Our ref: DOC22/233283
Your ref: SSD-12346552

Greater Western Battery Energy Storage System – EIS Exhibition

Thank you for your e-mail dated 2 March 2022 to the Biodiversity, Conservation and Science Directorate (BCS) of the Department of Planning and Environment (DPE) inviting comments on the Environmental Impact Statement (EIS) for the Greater Western Battery Energy Storage System.

BCS has reviewed the Biodiversity Development Assessment Report (BDAR) for the project. Our biodiversity recommendations are provided in **Attachment A** and detailed comments are provided in **Attachment B**.

Figure 10 shows the proposed development footprint, while Figure 11 shows the alternative footprint including the southern transmission line that was initially considered.

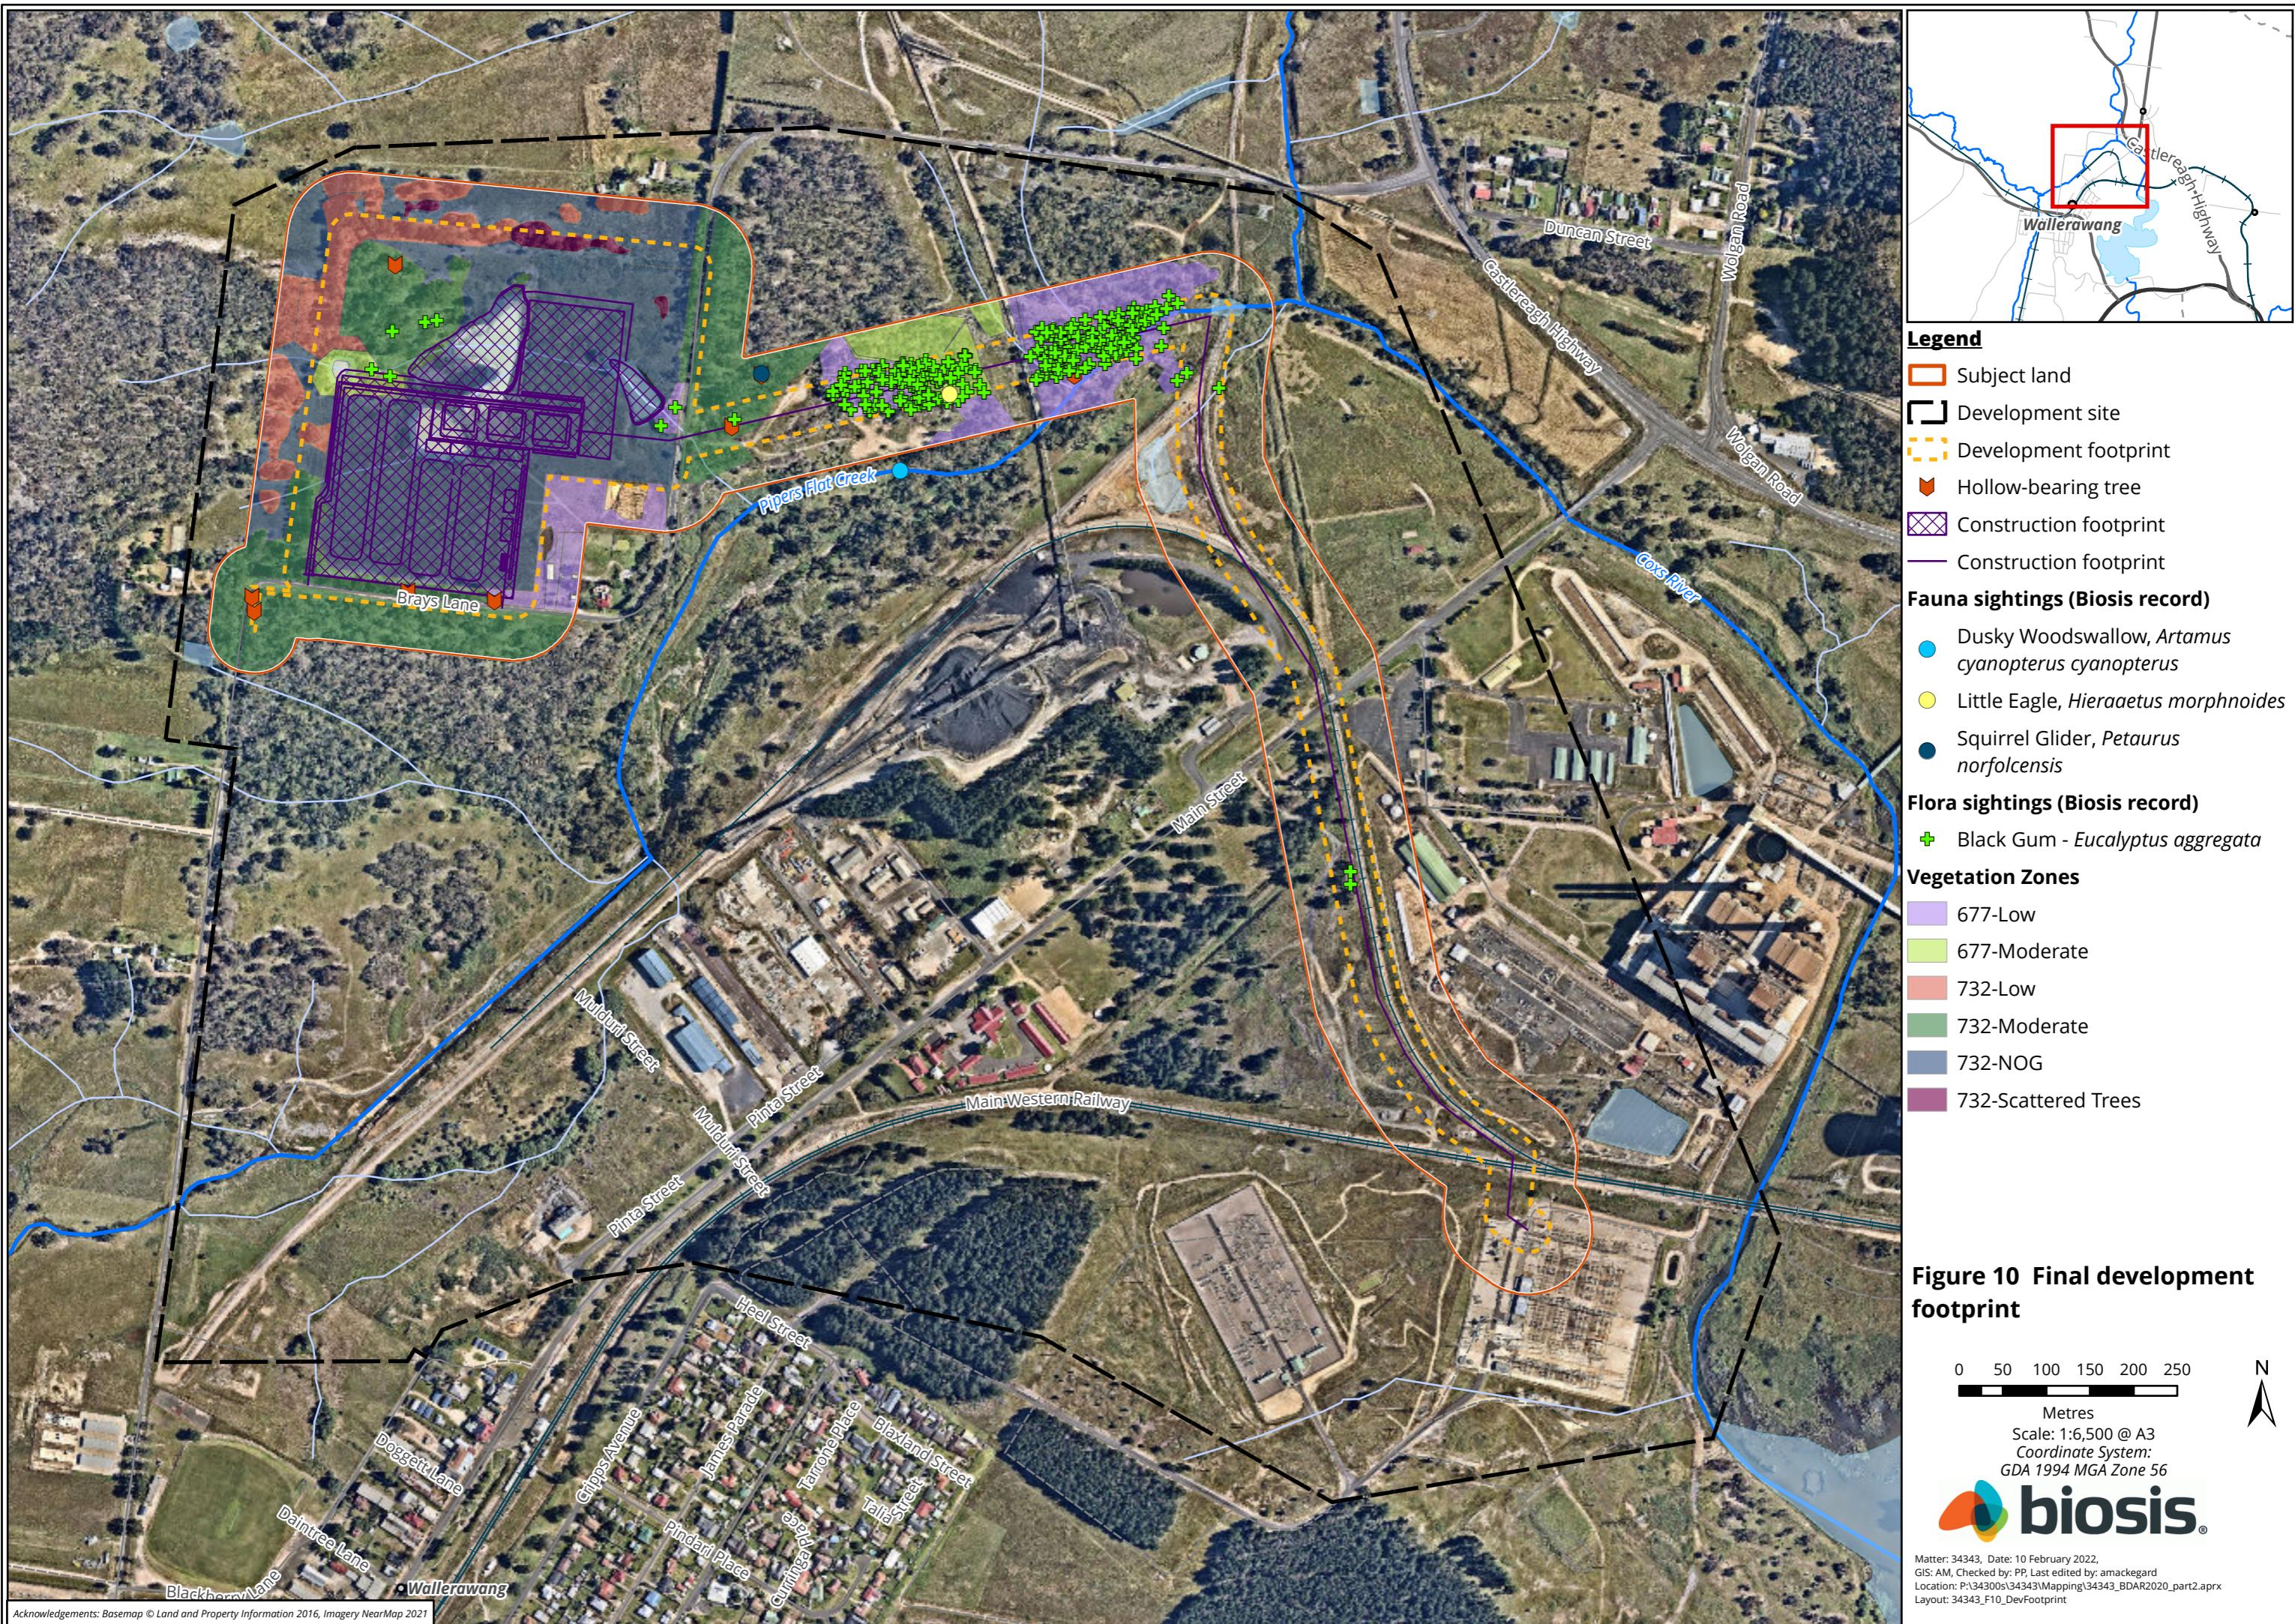
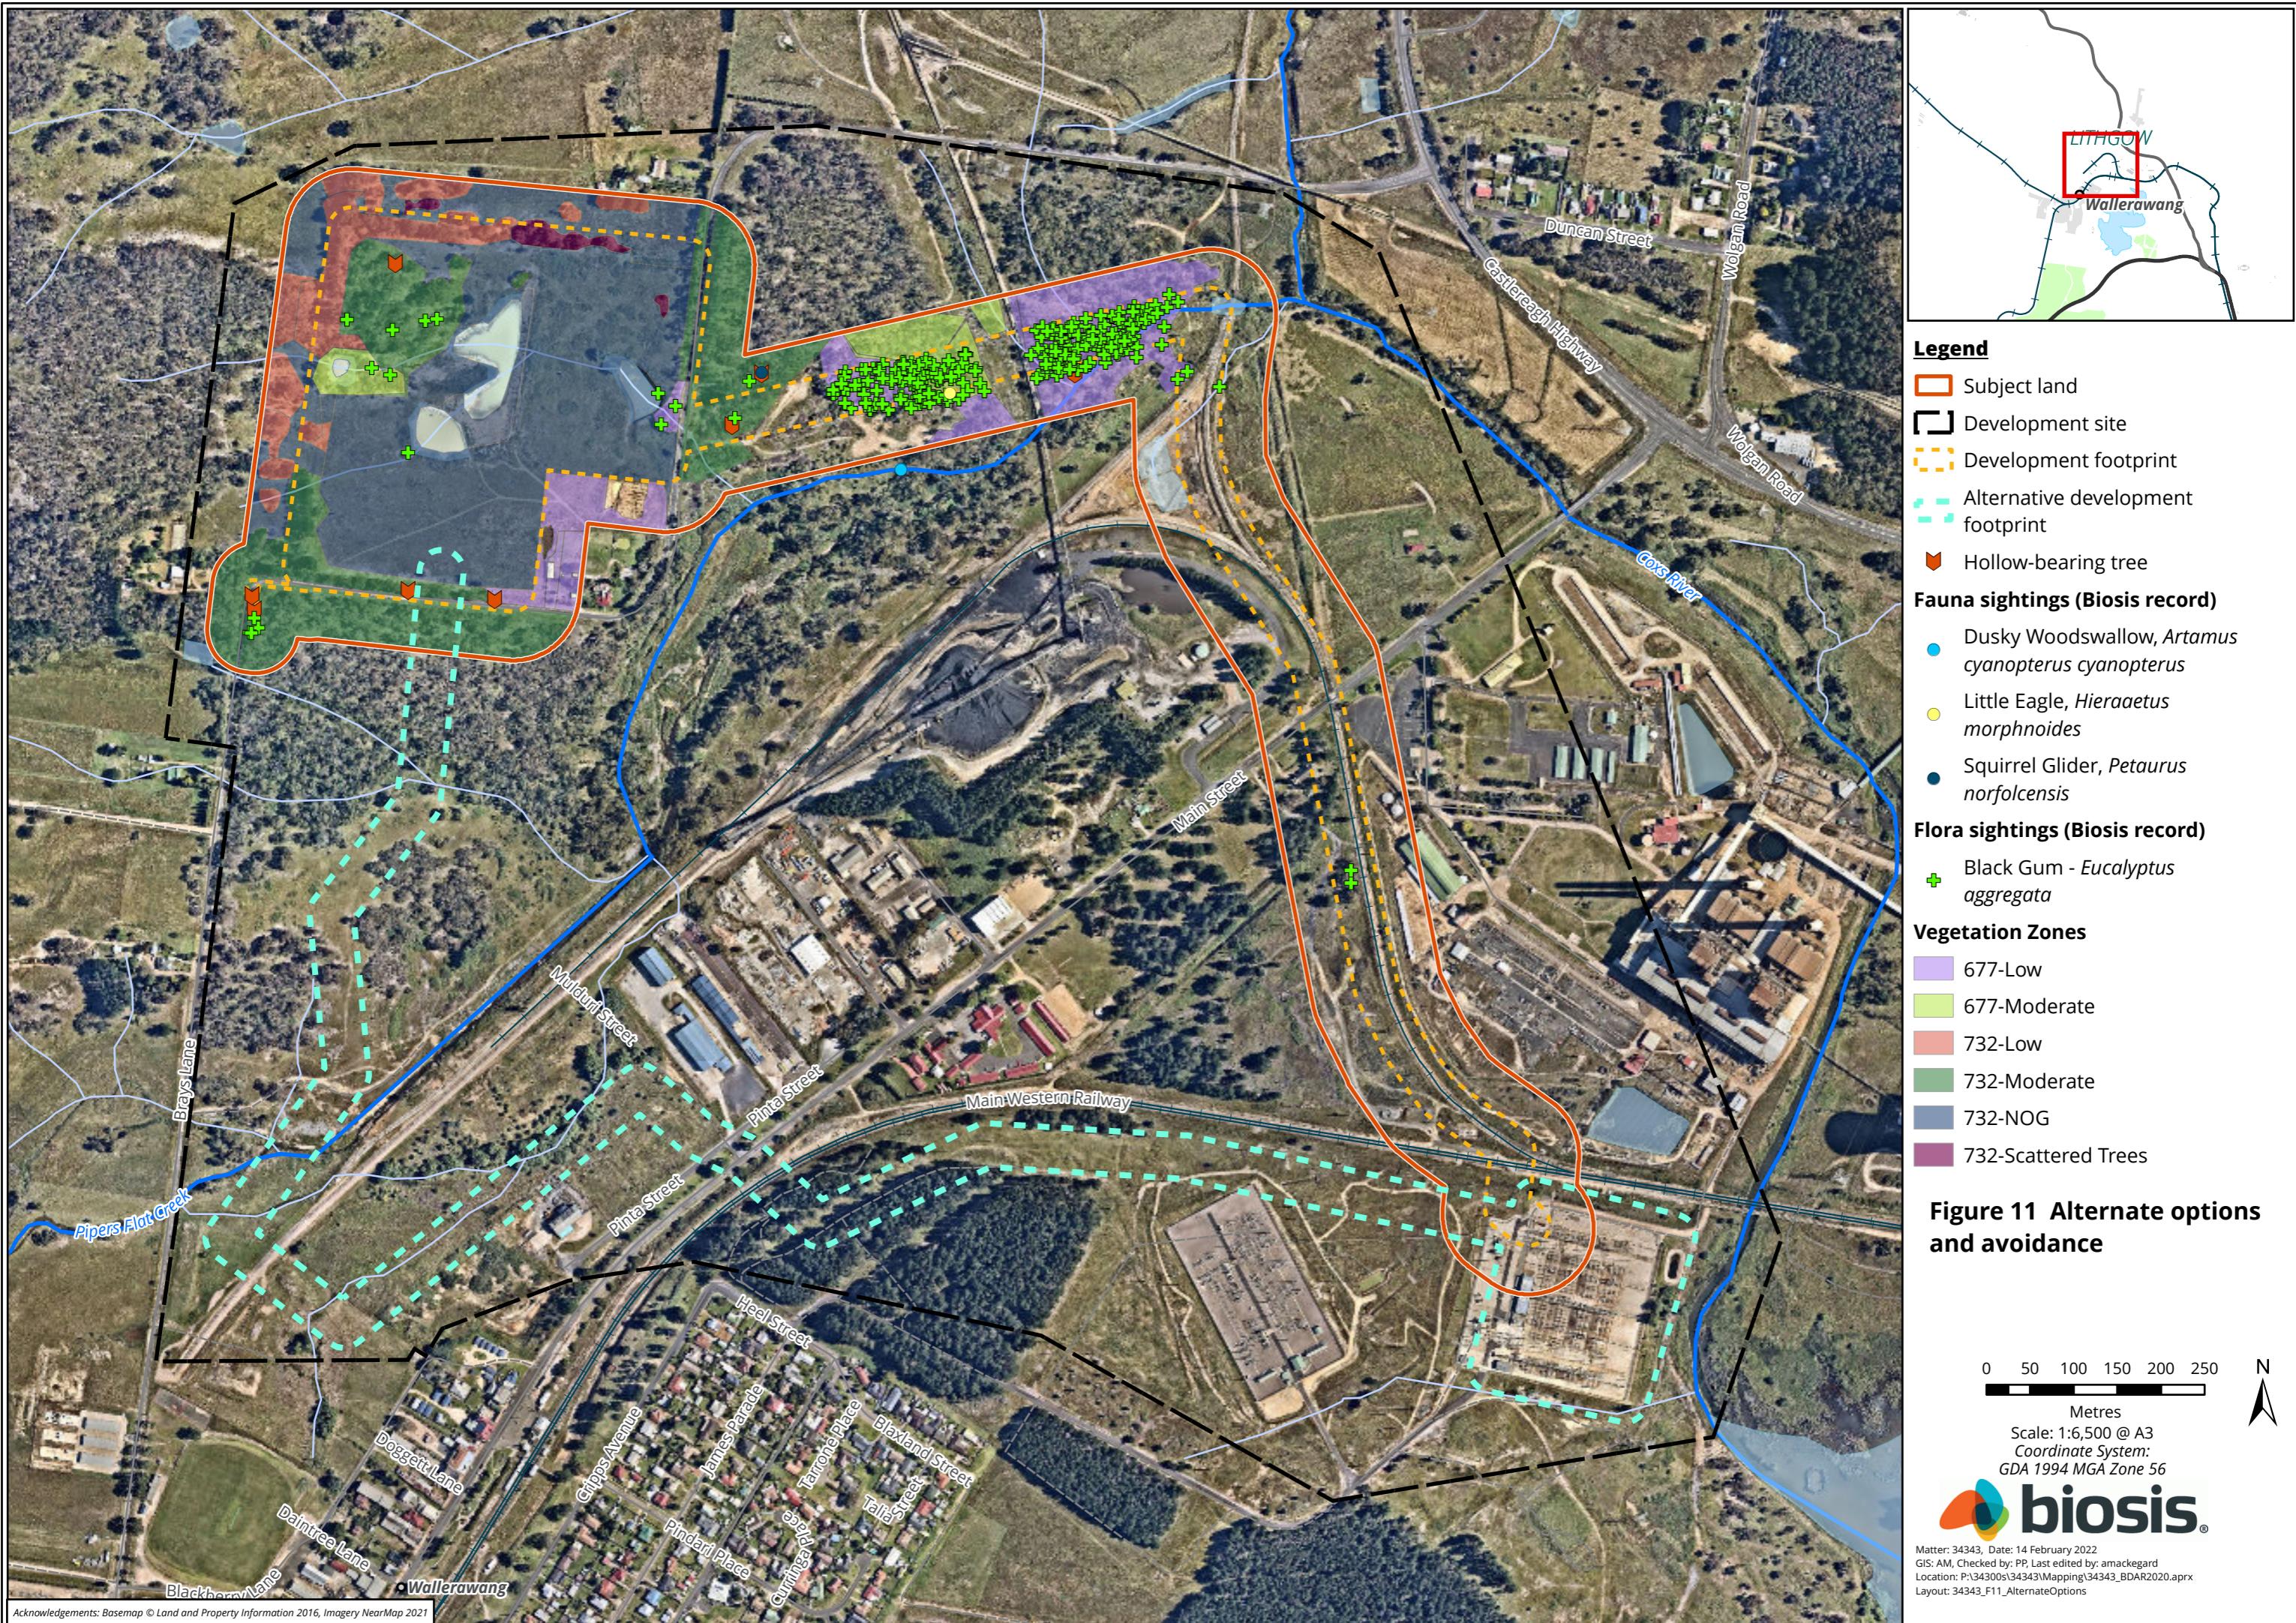
There are several figures within the BDAR which display the locations of all Black Gums located within the subject site. However, some figures show a significantly higher amount of Black Gums present which are absent from others.

As an example, Figure 11 displays individuals of Black Gum which are absent from Figure 10. The discrepancies between these two maps are shown in Figure 4 below.

From BCS review of the BAM-C only two individuals of Black Gum are proposed to be cleared for the project. However, there is additional Black Gums identified within the centre of the proposed construction footprint in some figures.

The inconsistencies between the figures in the BDAR should be updated, if any additional Black Gums are required for clearing the projects residual offset calculations this should also be updated.

- 10.1. Address the inconsistencies between figures within the BDAR and update the BAM-C calculations as necessary
